## Phase 1 School Lindfield Learning Village Eton Road, Lindfield

## Appendix 2 Response to Submissions

Appendix 2 is a summary of issues raised by Ku-ring-gai Council of 9 August 2017.

### Figure 5 Slope Assessment

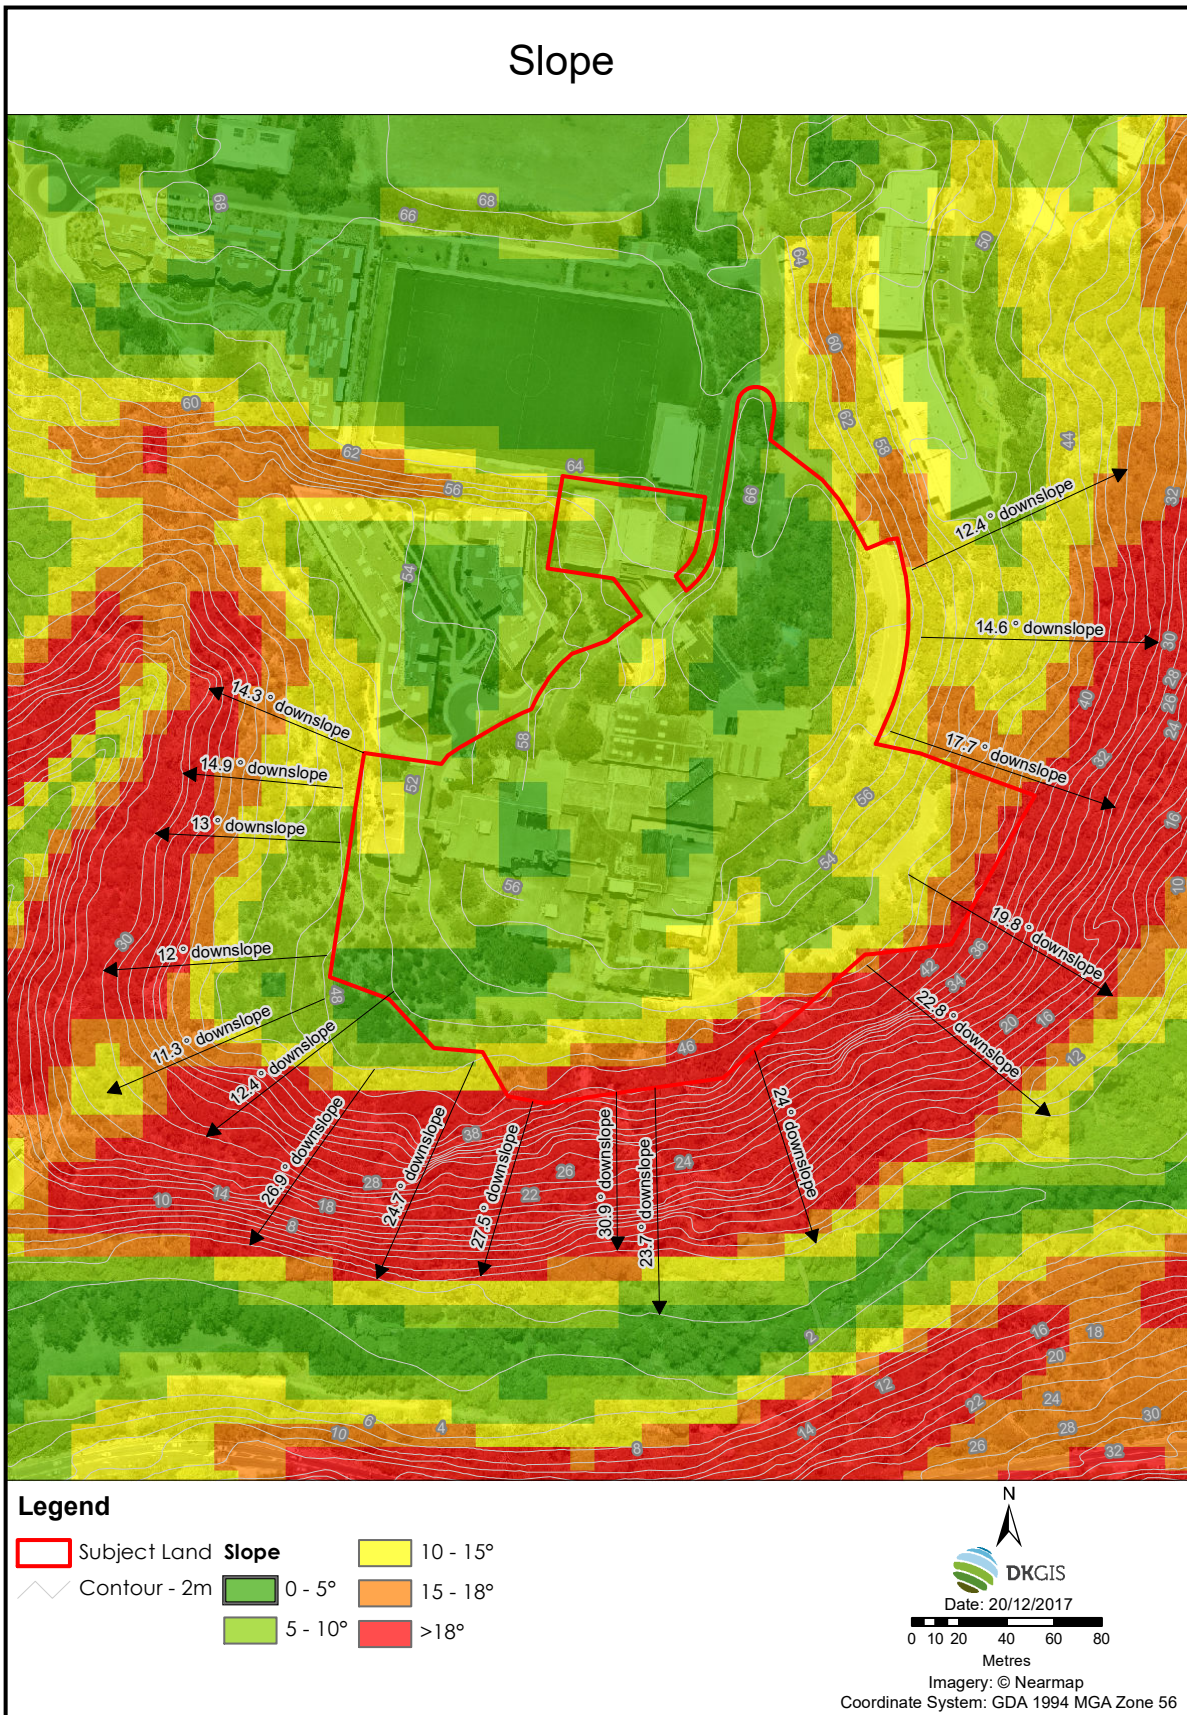
**1.8 Additional transects should be included within the bushfire design modelling as steeper gradients than the transects reported were recorded on the site.** It was identified onsite and also validated in reviewing topographic mapping of the subject area (0.5m contours) that there are additional transects which are located on steeper gradients that should be considered. The gradient is a fundamental input in the bushfire design modelling and an increase in downslope gradients results in larger flame length, higher radiant heat flux, faster rate of spread and higher fire intensity.

**RESPONSE: Addressed** - refer to supporting Bushfire Assessment Report prepared by Blackash (Section 8.5 and Figure 5).

As part of the detailed site assessment undertaken additional slope transects have been included in order to more accurately reflect the effective slope present within the hazard areas to the south of LLV.
